from
**Southern
Water**

Your ref
LU/119/25/PL

Proposal: Extension of industrial unit and installation of new palisade fencing gates to adjoin existing dropped kerb (resubmission following LU/303/24/PL). This application is in CIL Zone 4 (Zero Rated) as other development..

Site: Unit 11a To Unit 11d Lineside Way Littlehampton BN17 7EH.

Map Title: SW Print

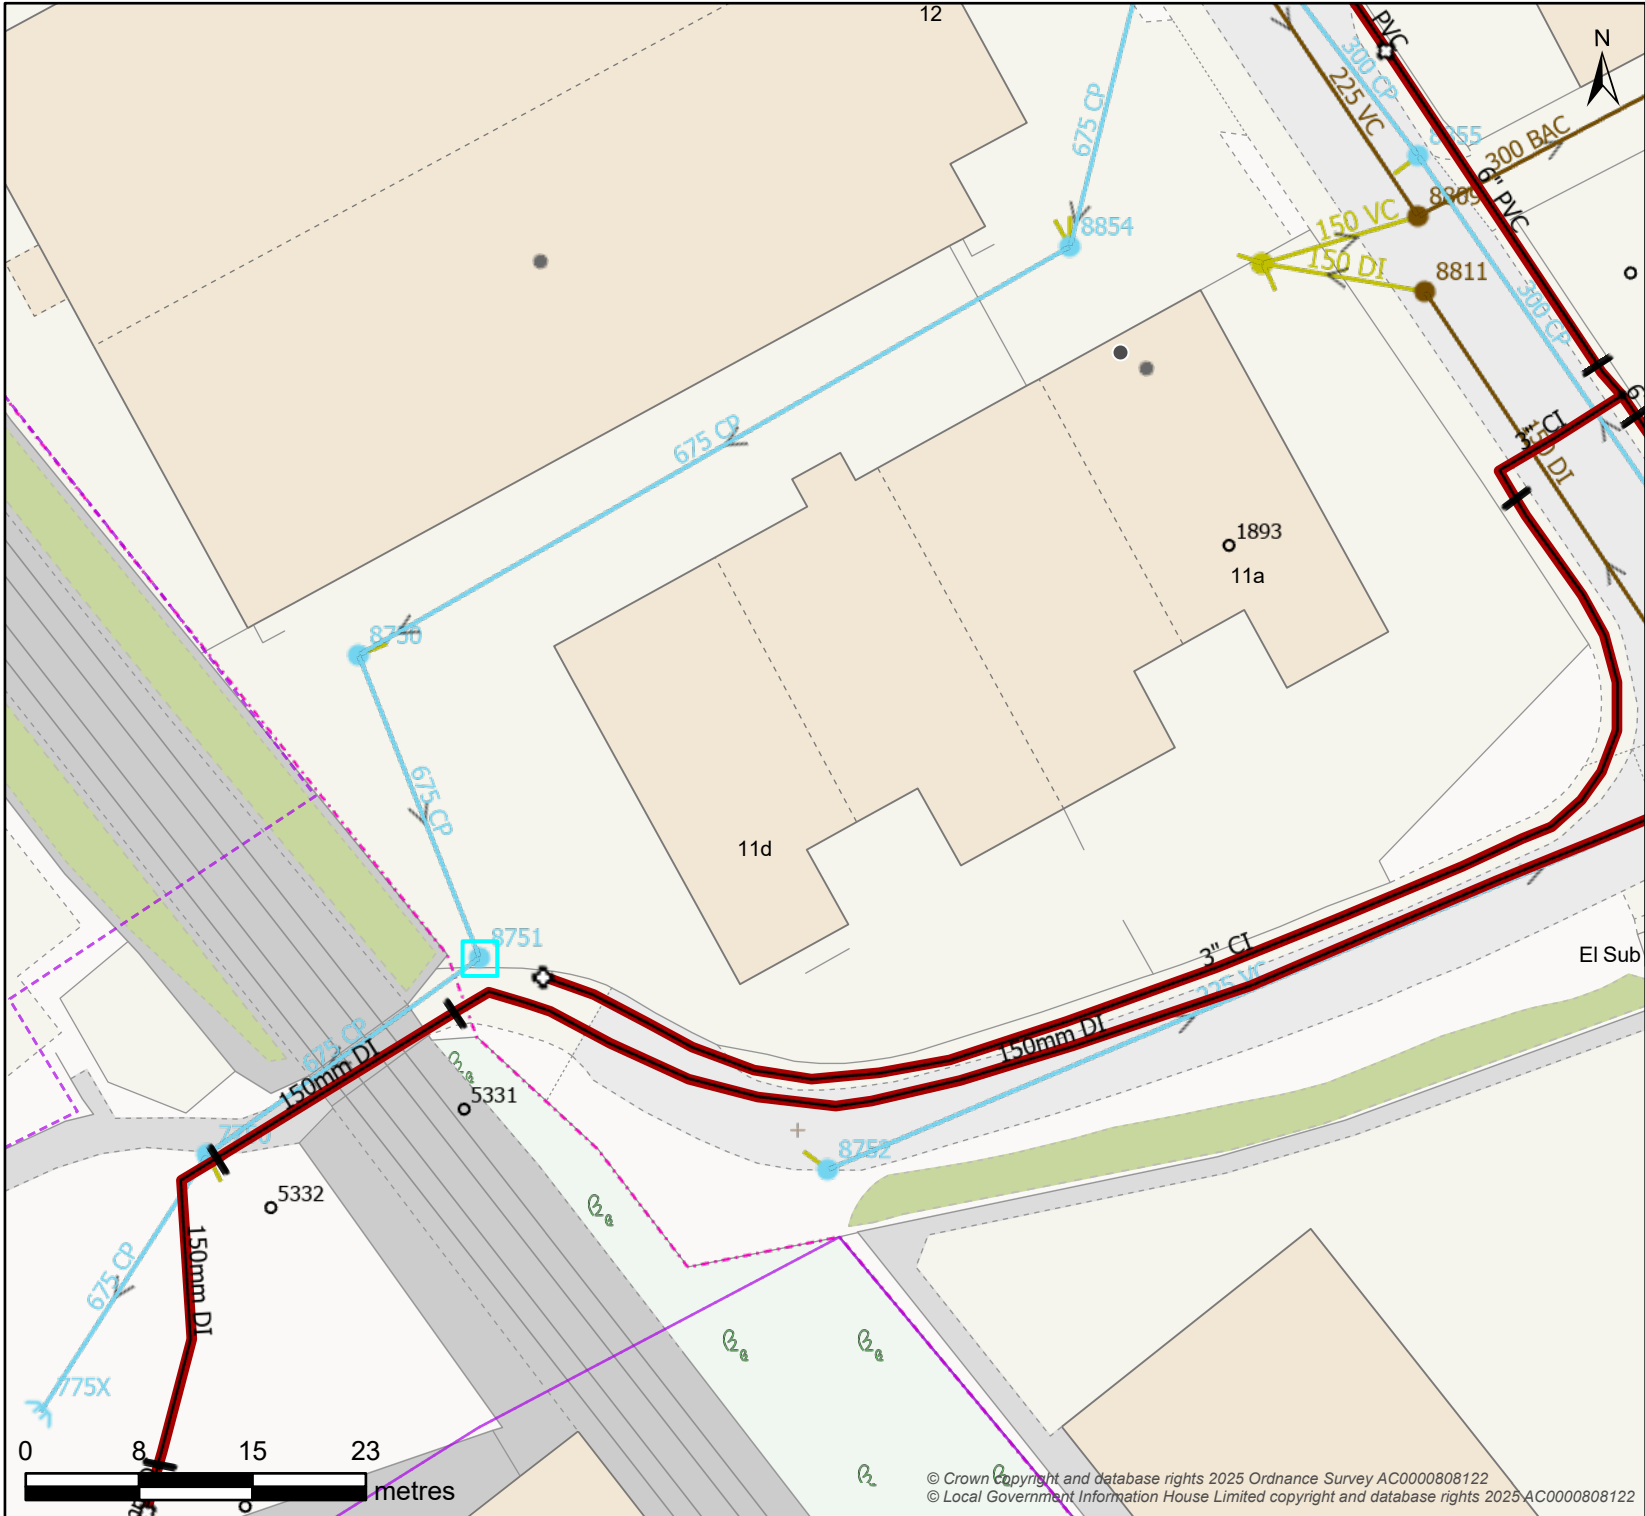
Please see the attached extract from Southern Water records showing the approximate position of our existing sewer and water main assets crossing/in the vicinity of the development site. The exact position of the public assets must be determined on site by the applicant in consultation with Southern Water before the layout of the proposed development is finalised. To get in contact to confirm the exact position of the asset please visit;

Existing Gravity Sewer - tree, buildings, assets within stand-off distance

The 675 mm diameter gravity sewer requires a clearance of 3.5 metres on either side of the gravity sewer to protect it from construction works and to allow for future maintenance access.

No development or tree planting should be carried out within 3.5 metres of the external edge of the public gravity sewer without consent from Southern Water. All existing infrastructure should be protected during the course of construction works. Please refer to:

The attached plan shows that the proposed development is being built over a public sewer or within 3m of a public sewer. An investigation of the sewer is required to confirm its size and depth, ascertain its condition, number of properties served and potential means of access before any decision can be made as to whether it would be acceptable for the proposed development to be

built close to the sewer. If the sewer in question is found to be no greater than 225mm in diameter and no deeper than 3 meters, the development may be allowed, subject to the following conditions:

1. No construction works parallel to the sewer within 500mm (in plan).
2. Where within three metres, foundations depth to be taken down 150mm below the invert level of the sewer.

It appears that the developer is intending to build close to a public foul sewer which is crossing the site. Building over a "public sewer" is not normally permitted by Southern Water. However, under certain circumstances building over a minor sewer may be allowed. The conditions and application associated with the build-over/close-to a public sewer are available at Southern Water's Get Connected service: <https://developerservices.southernwater.co.uk>.

In order to protect public sewers, Southern Water requests that if consent is granted, the following condition is attached to the planning permission; The developer must agree with Southern Water, prior to commencement of the development, the measures to be taken to protect the public sewers.

In order to protect drainage apparatus, Southern Water requests that if consent is granted, the following condition is attached to the planning permission; prior to the commencement of development, the developer must advise the local authority, in consultation with Southern Water, of measures which will be undertaken to protect the public sewers.
